PLANNING AMENDMENT

Drawing Title:
Proposed Boundary Treatments

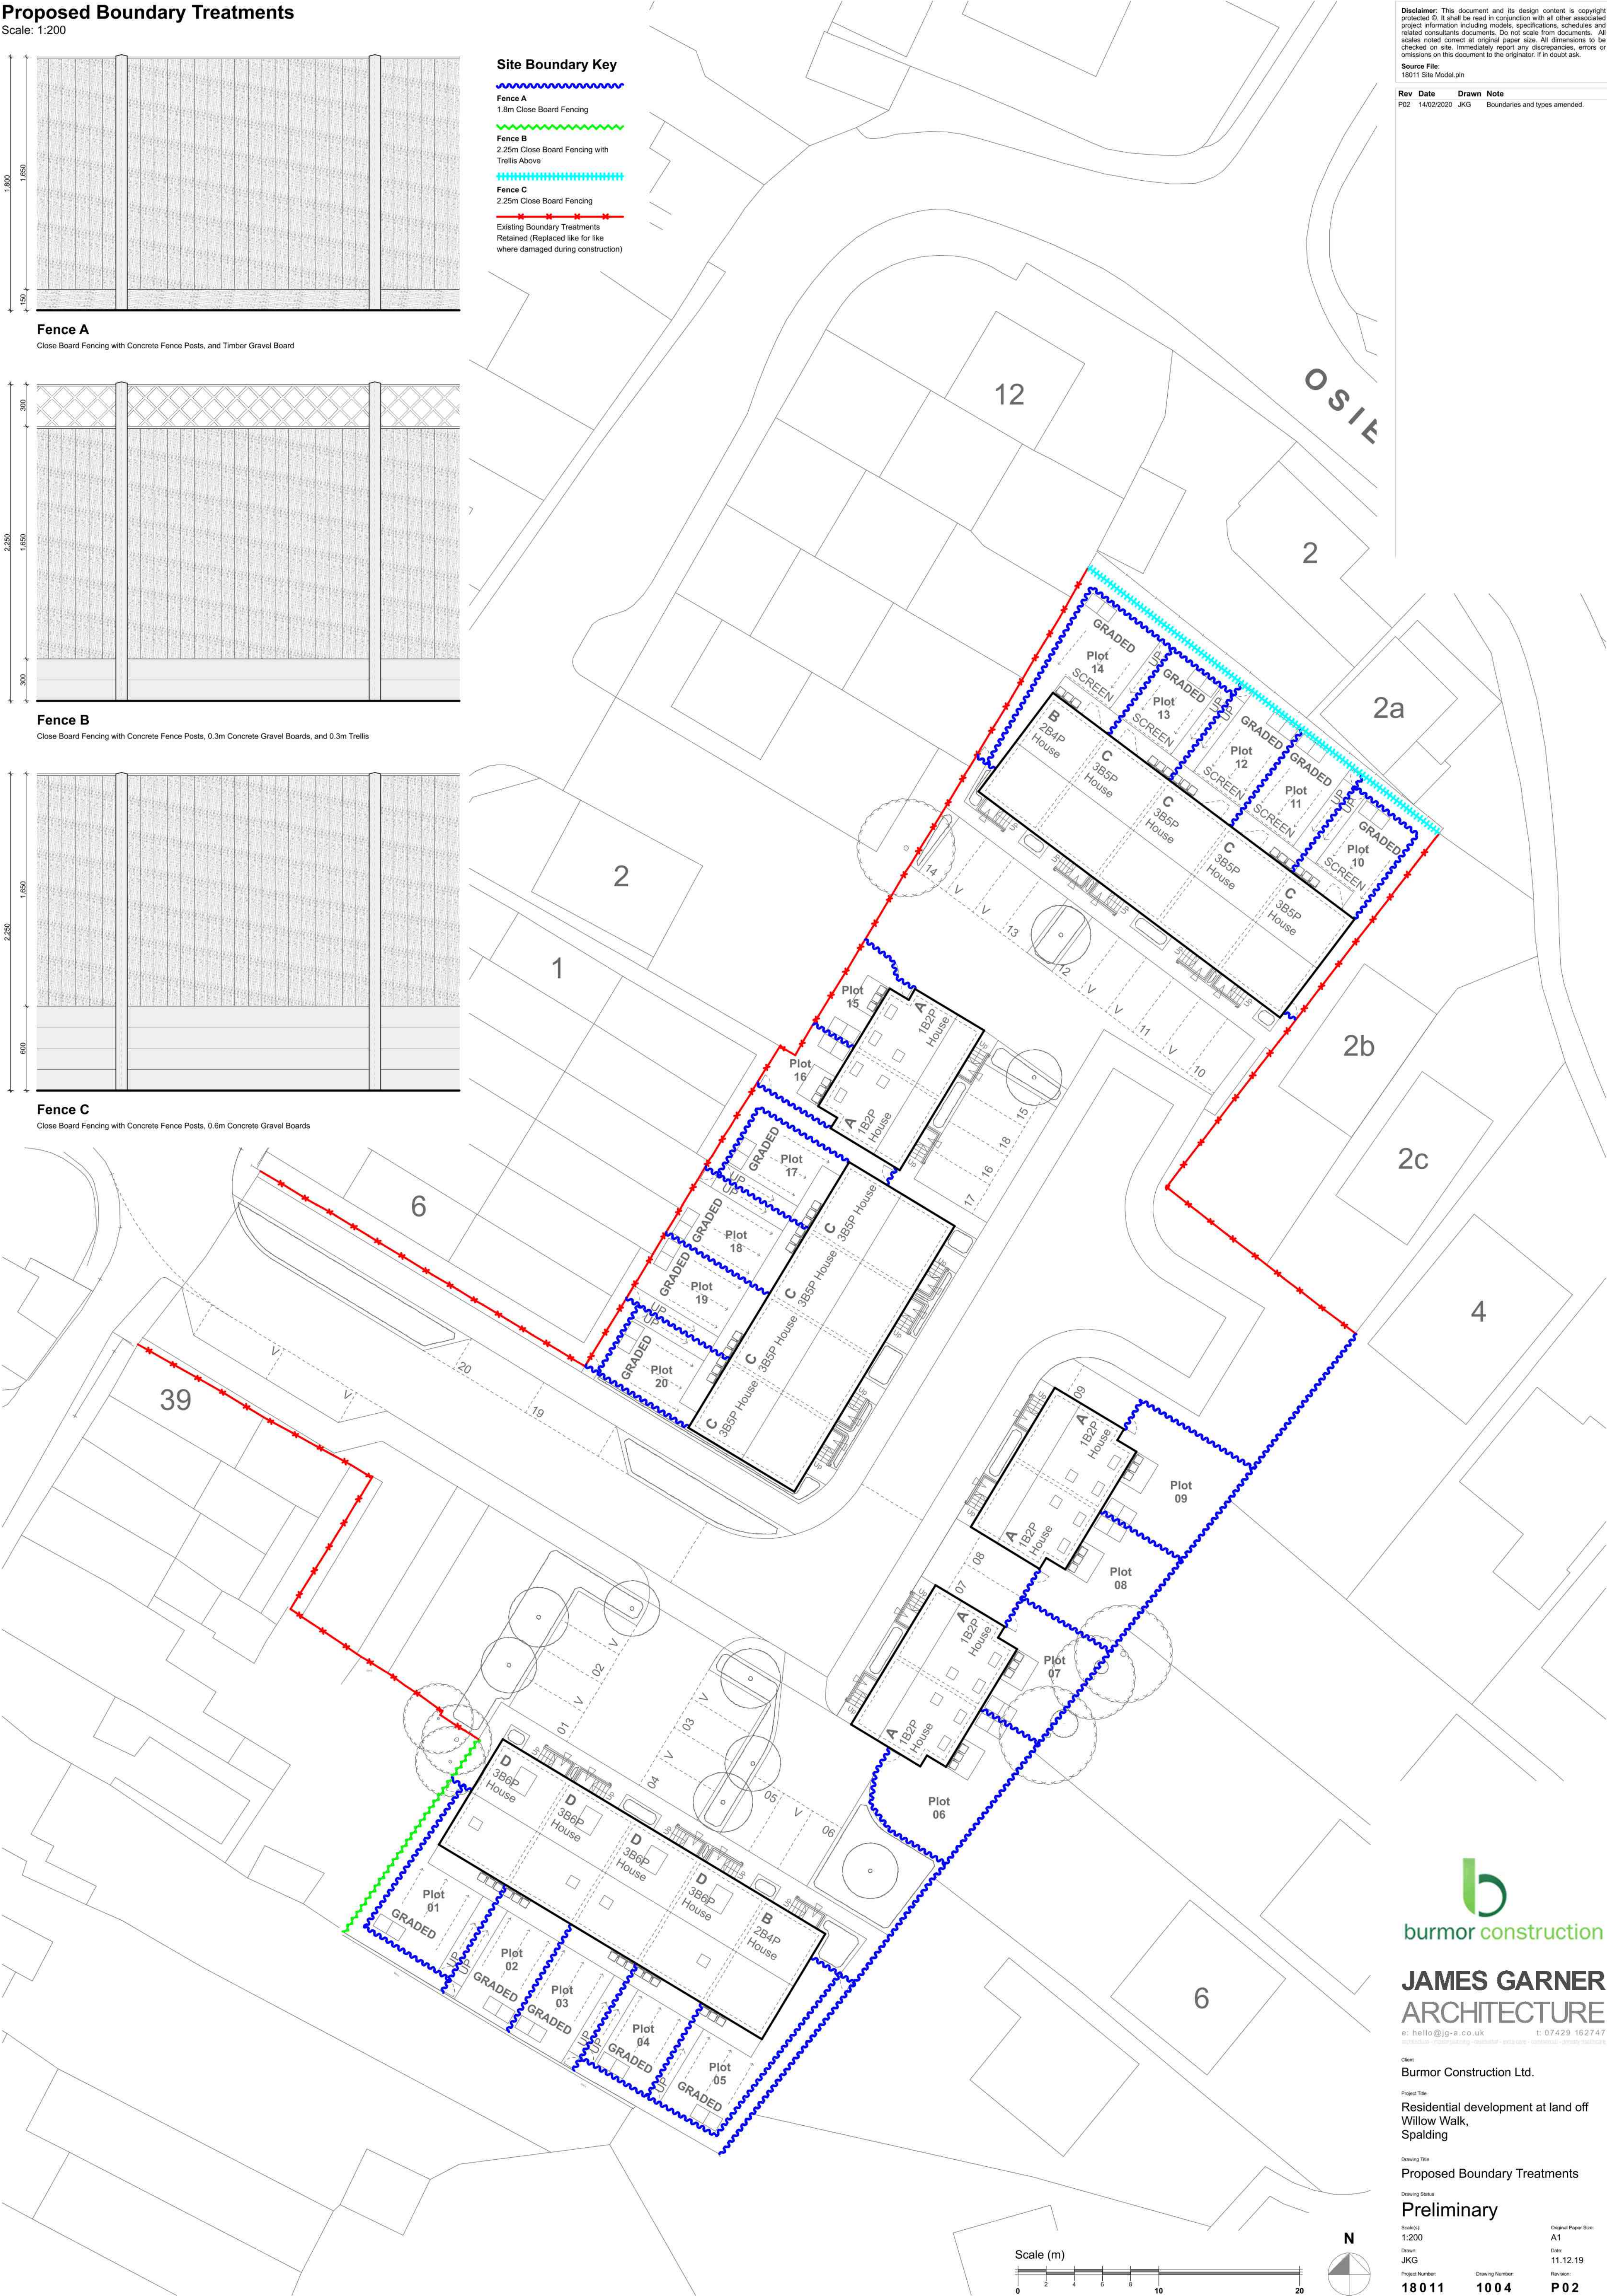
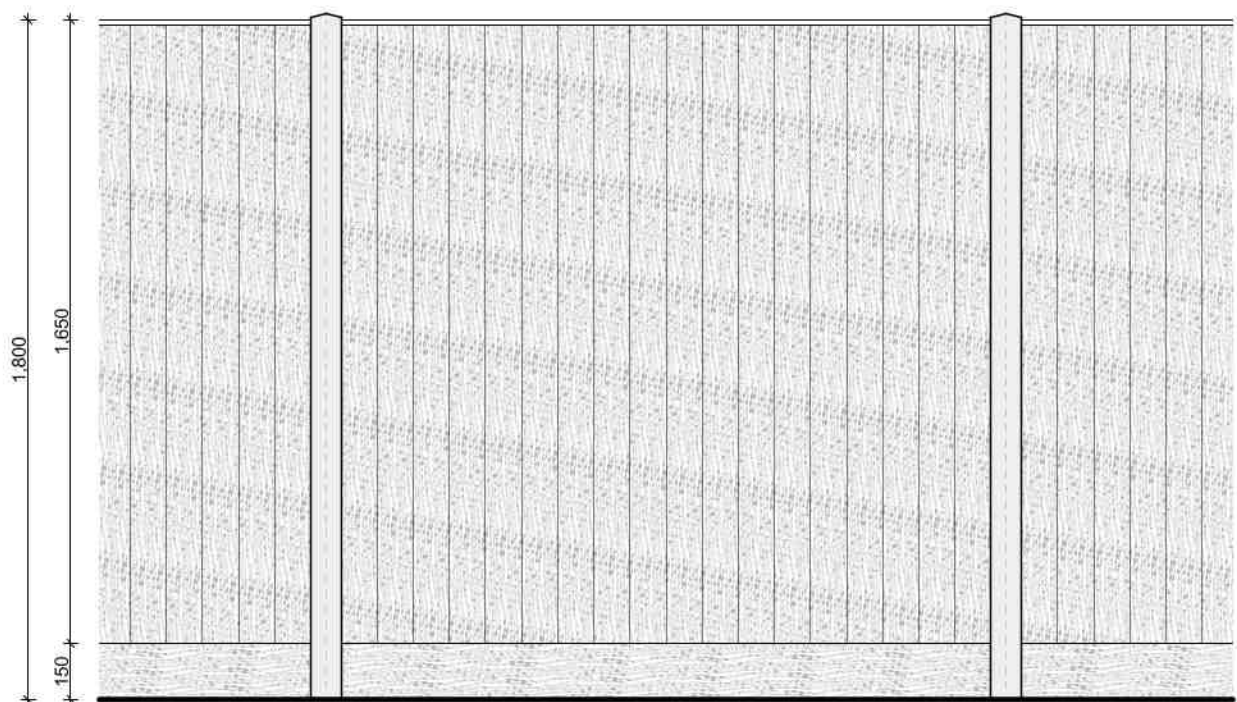
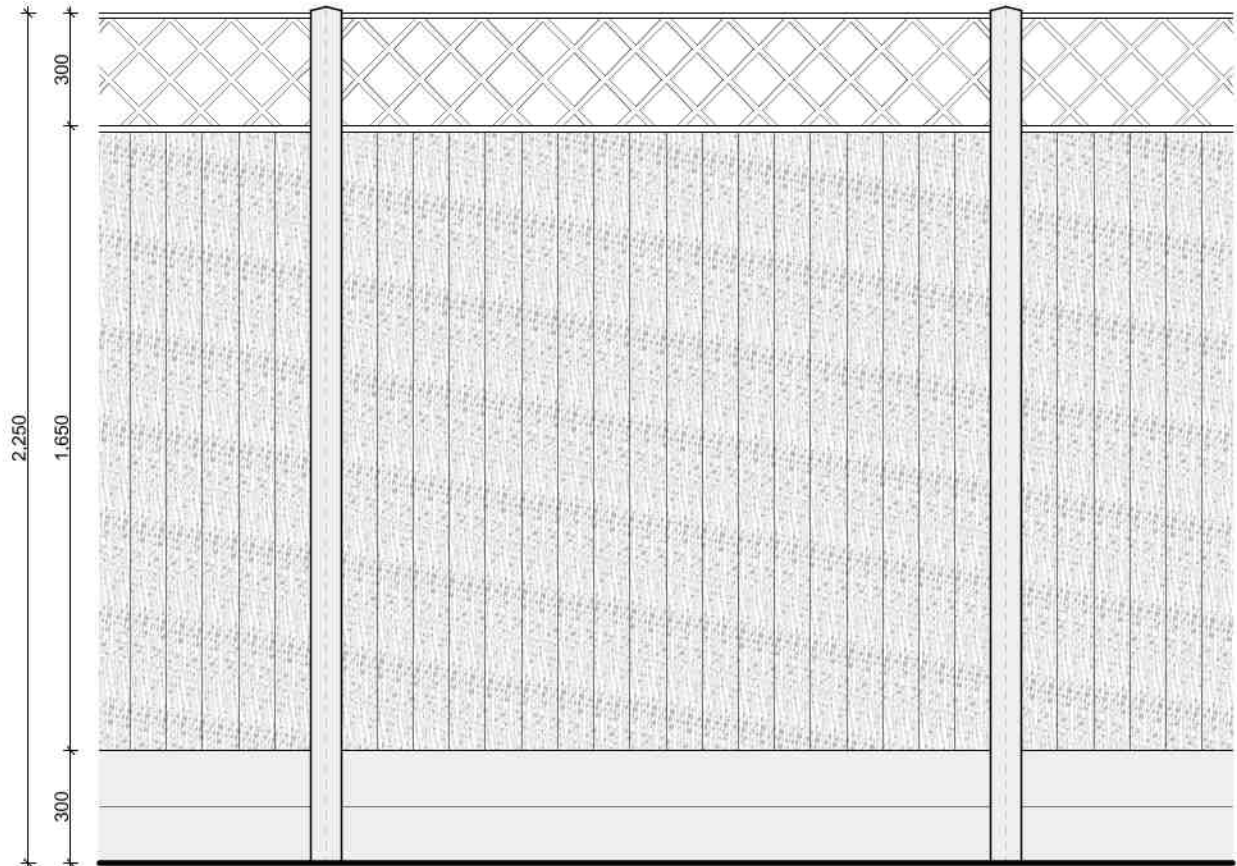
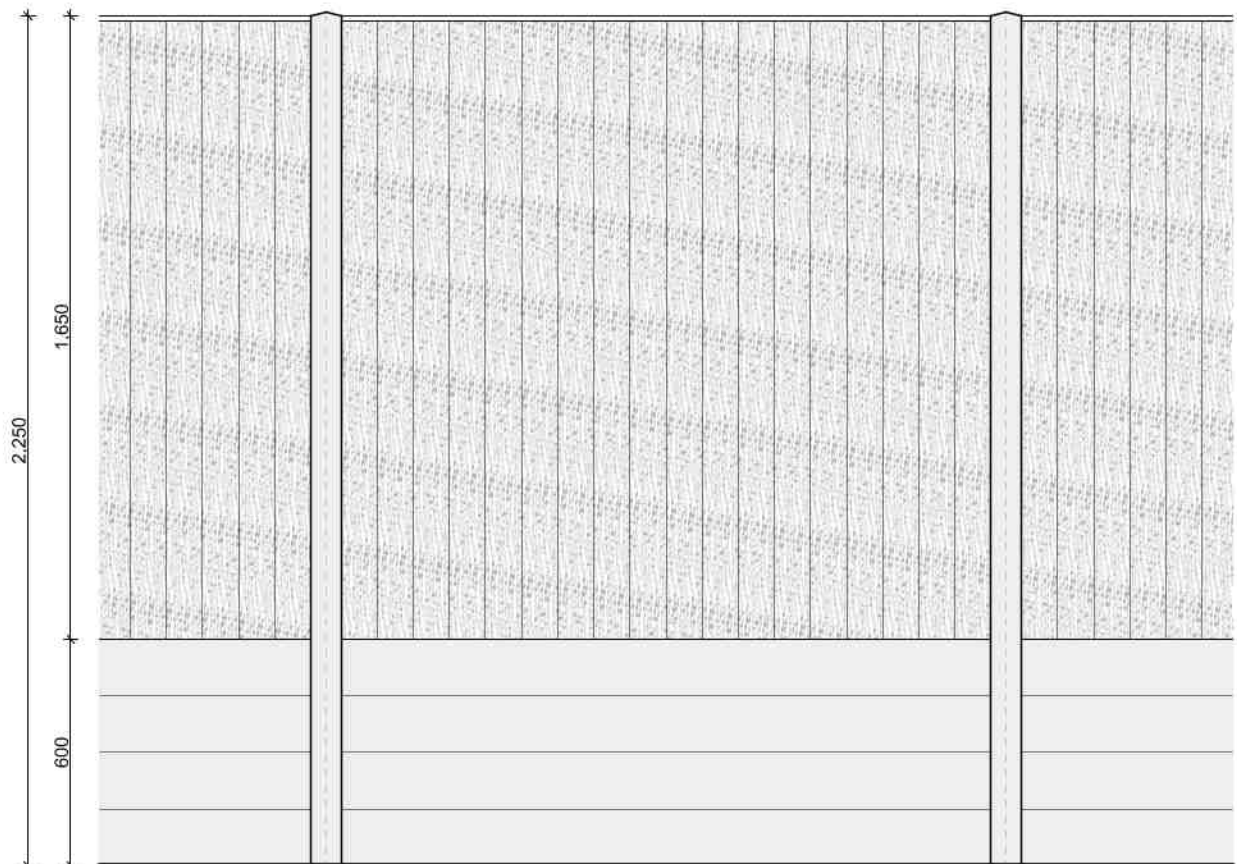
FULL DESCRIPTION OF DEVELOPMENT OF CURRENT APPLICATION THAT THIS AMENDMENT RELATES TO		
State details of amendments proposed. (Give a full detailed list of the changes, and also mark these clearly on the accompanying plans. Only the changes listed here will be considered)	Amendments to boundary treatment - following site meeting	
State drawing numbers of the current submission	18011 1004-P02 Proposed Boundary Treatments	
Has this amendment been requested by the Council? (If so, state Officer dealing with the application)	YES/ NO	Polly Harris-Gorf
Describe any part of the original development which is excluded by virtue of the amendment, and state any alteration to plot numbers	N/A	
Has a similar amendment been submitted under Building Regulations? (If so, state Building Control Surveyor dealing with application)	YES/ NO
